Subject: FW: A/3/18/PL - Land at Arundel Road/A27, Angmering - Change of use of land to storage (B8 Storage or Distribution)

Subject: RE: A/3/18/PL - Land at Arundel Road/A27, Angmering - Change of use of land to storage (B8 Storage or Distribution)

Drawing:
1711056-SK01

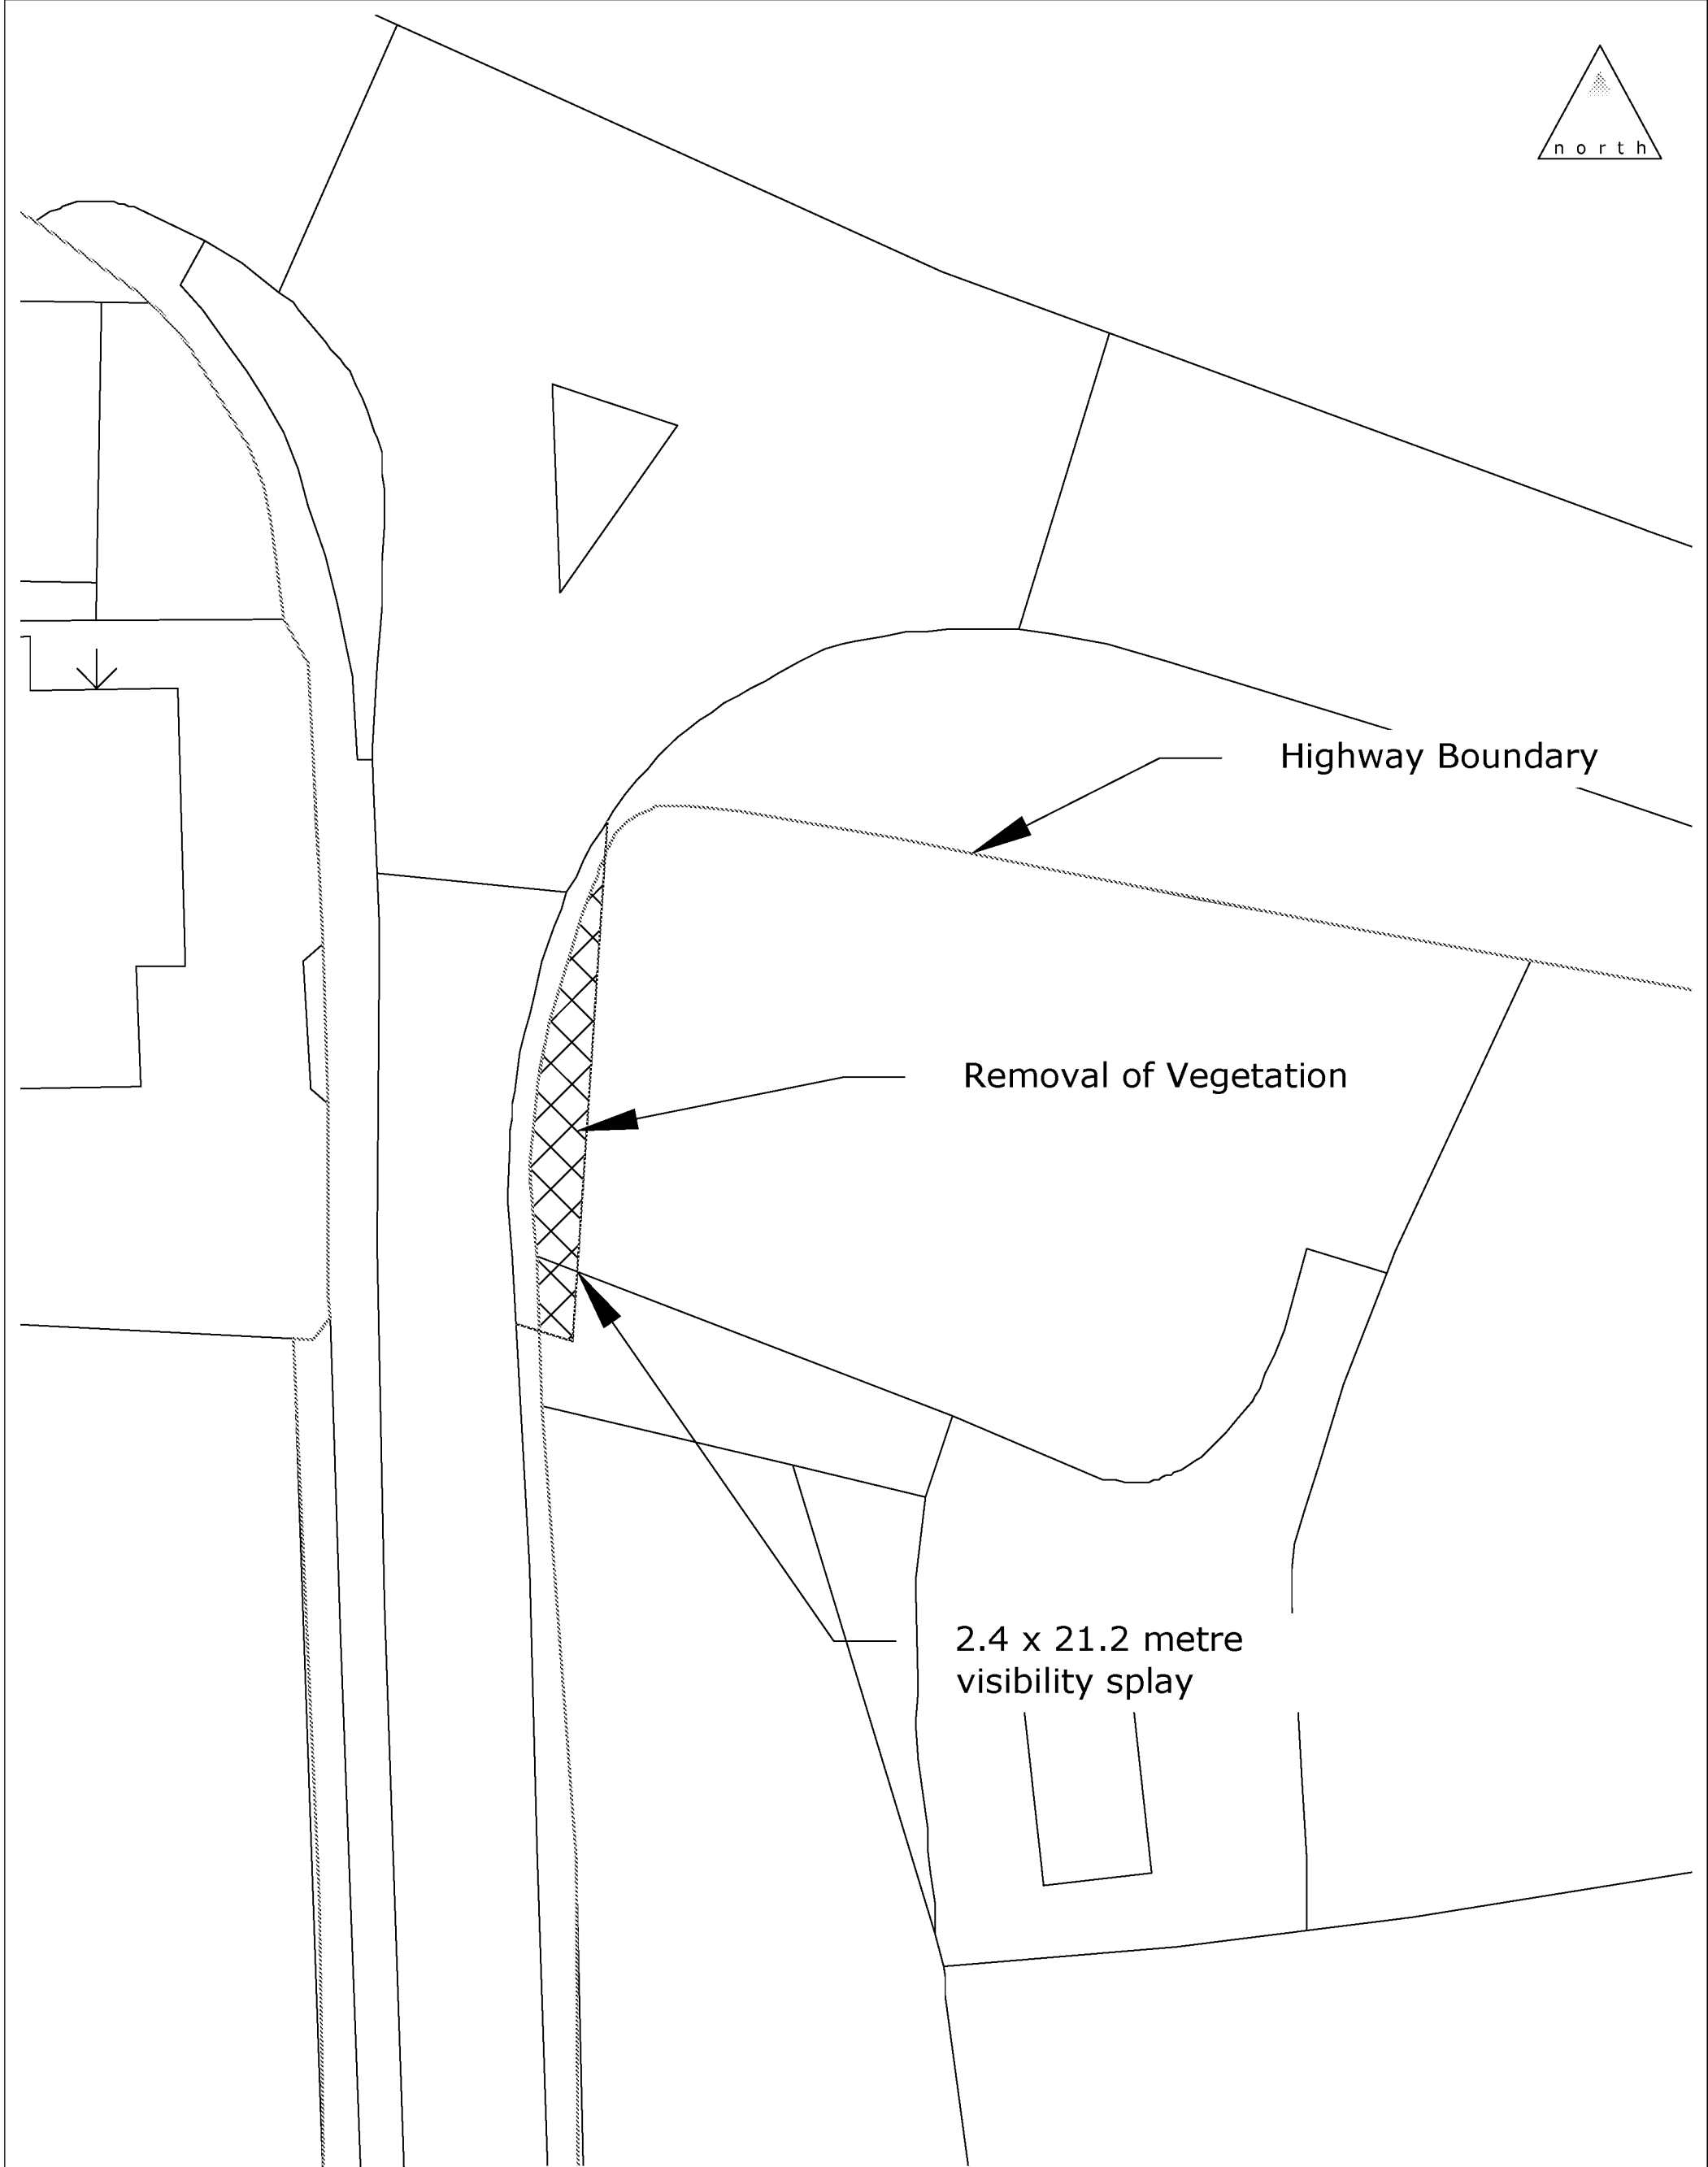
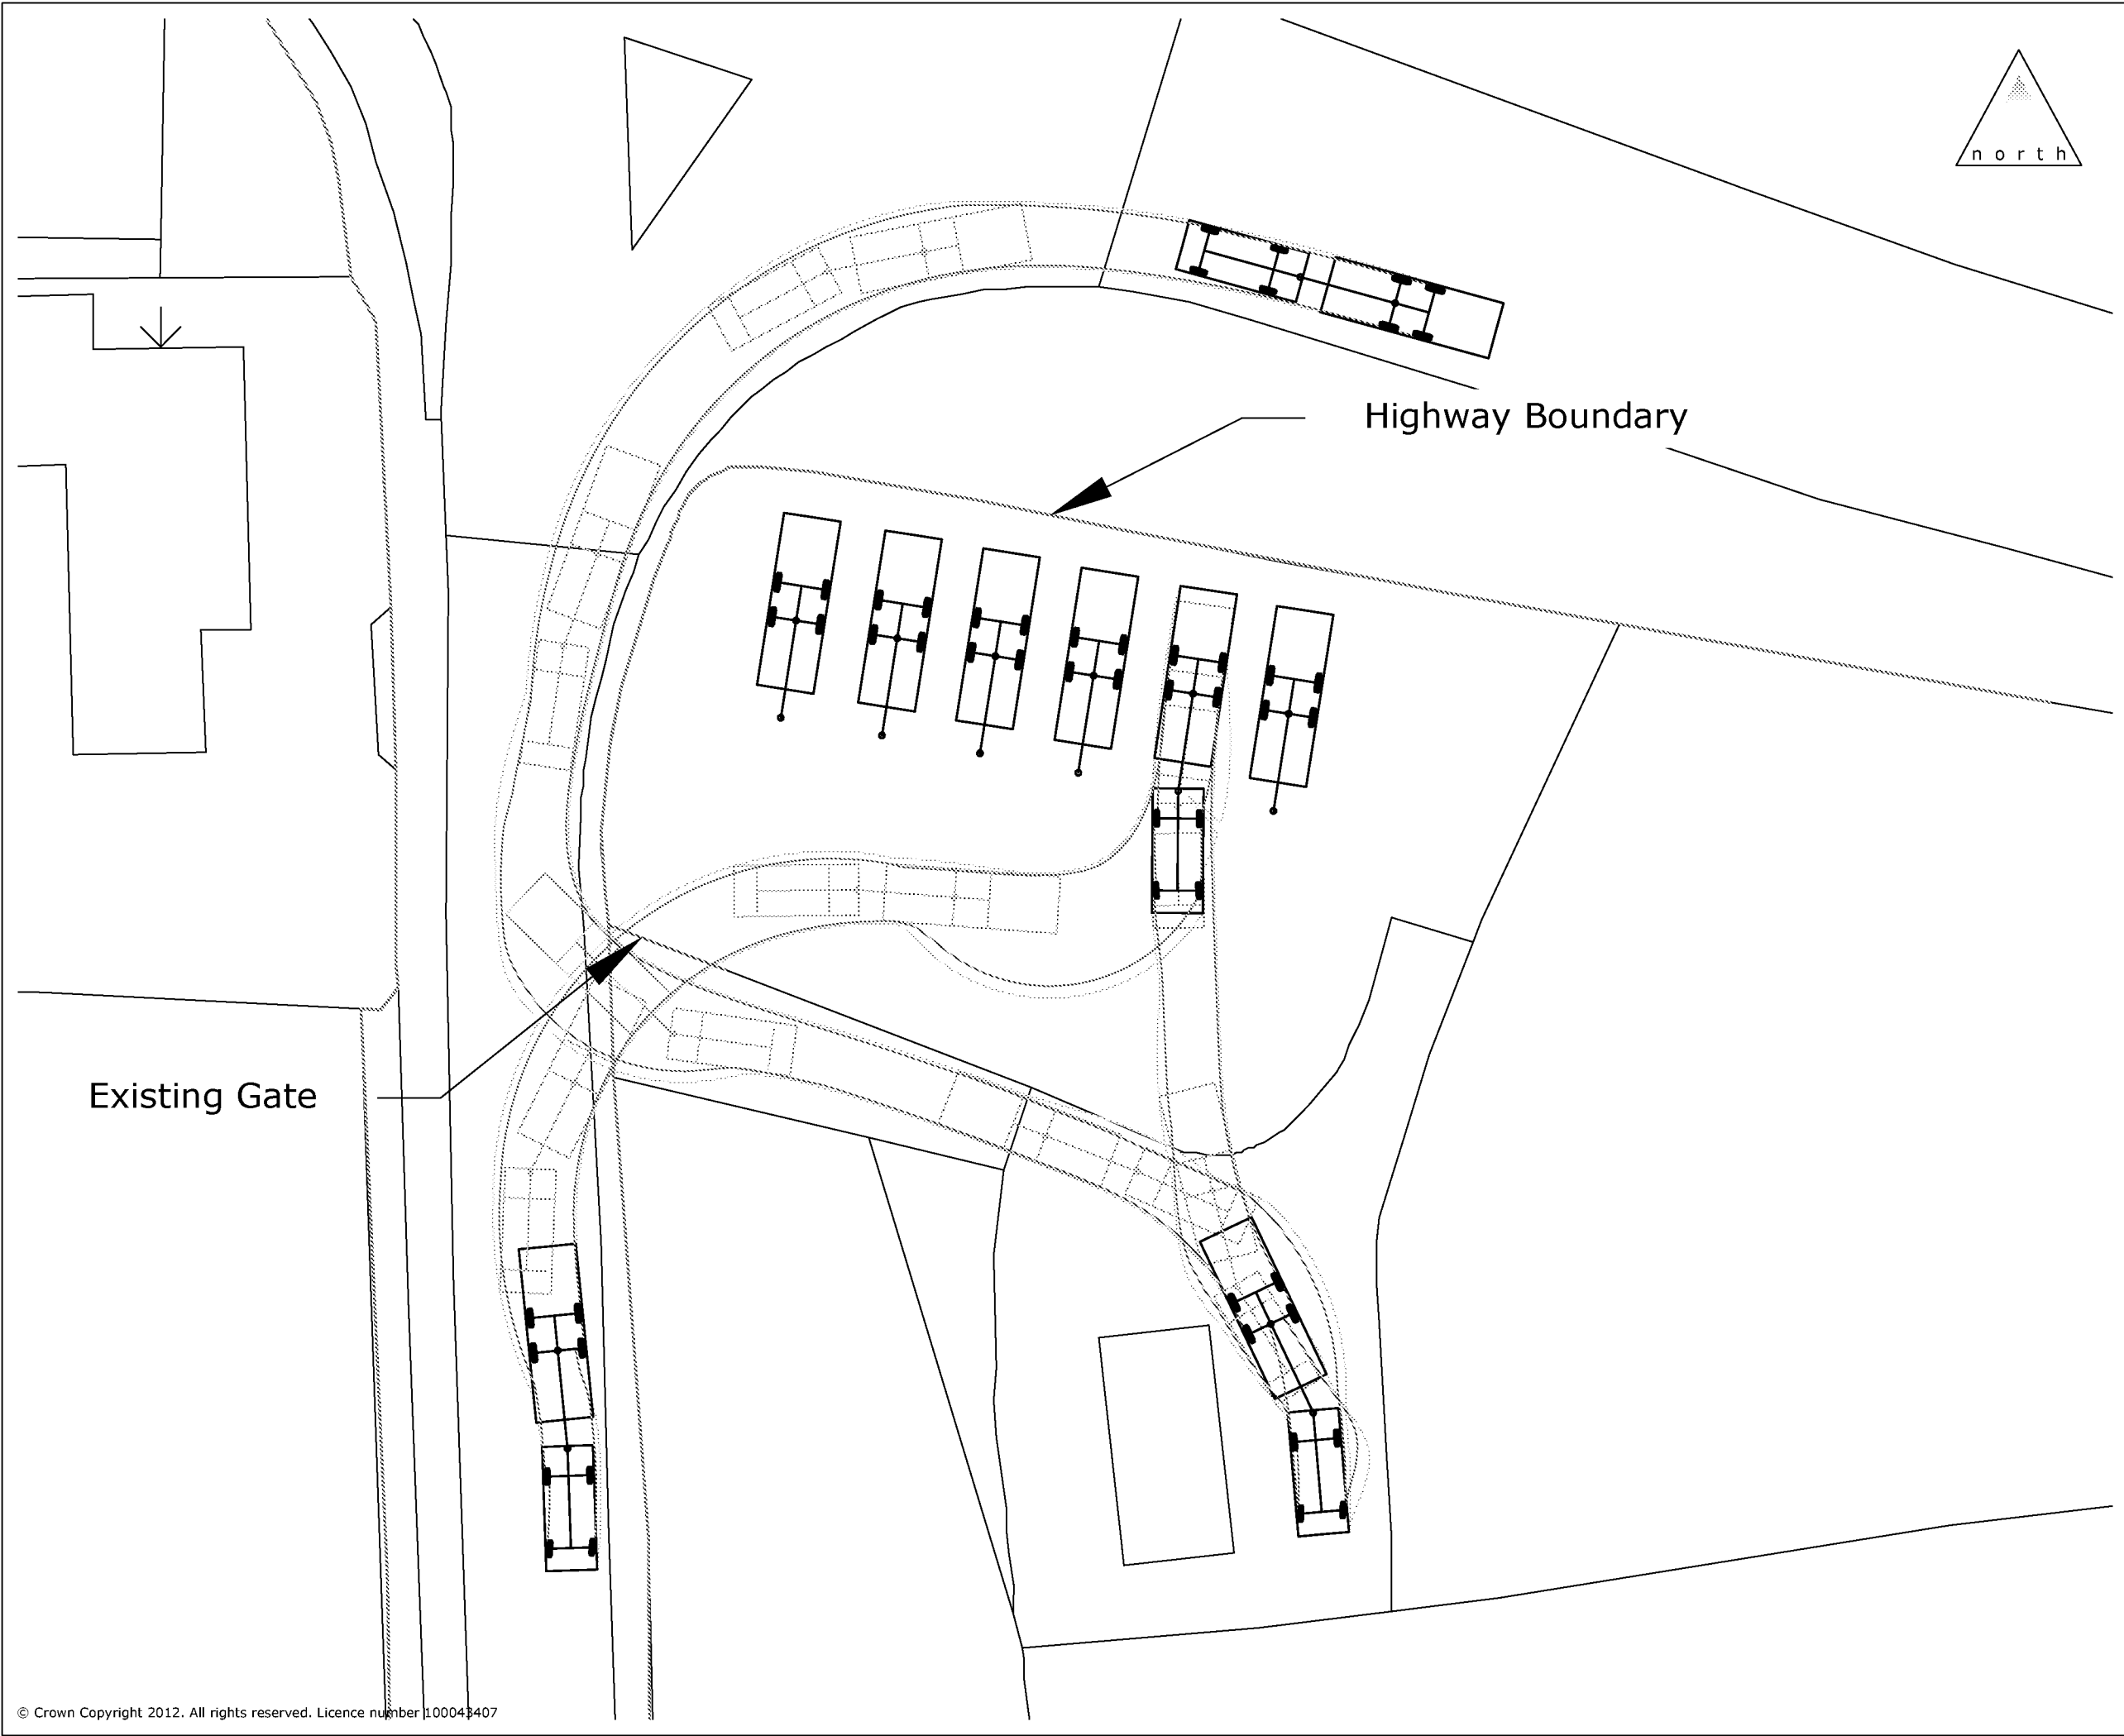
I don't see how appropriate visibility splays can be created south (trailing direction) without the use of 3rd party land. While I would accept that appropriate visibility splays to the north can be created as per the data provided the formation of these splays may be unacceptable to the Local Planning Authority due to the amount of vegetation and trees that will need to be removed. Presumably page 11 of the technical note is where the speed survey was undertaken?

- If we were to go down the route of not removing the hedging / vegetation to create the visibility splays, but simply lowering them they would need to be reduced in height to 0.6 metres, given there is no footway in this location there would be some scope that any lowering could be to 0.8 / 0.9 metres as the height of a drivers eye in a private motor vehicle is accepted as being 1.05 metres. Regardless this is going to have a significant impact on the street scene which would be a consideration for you.
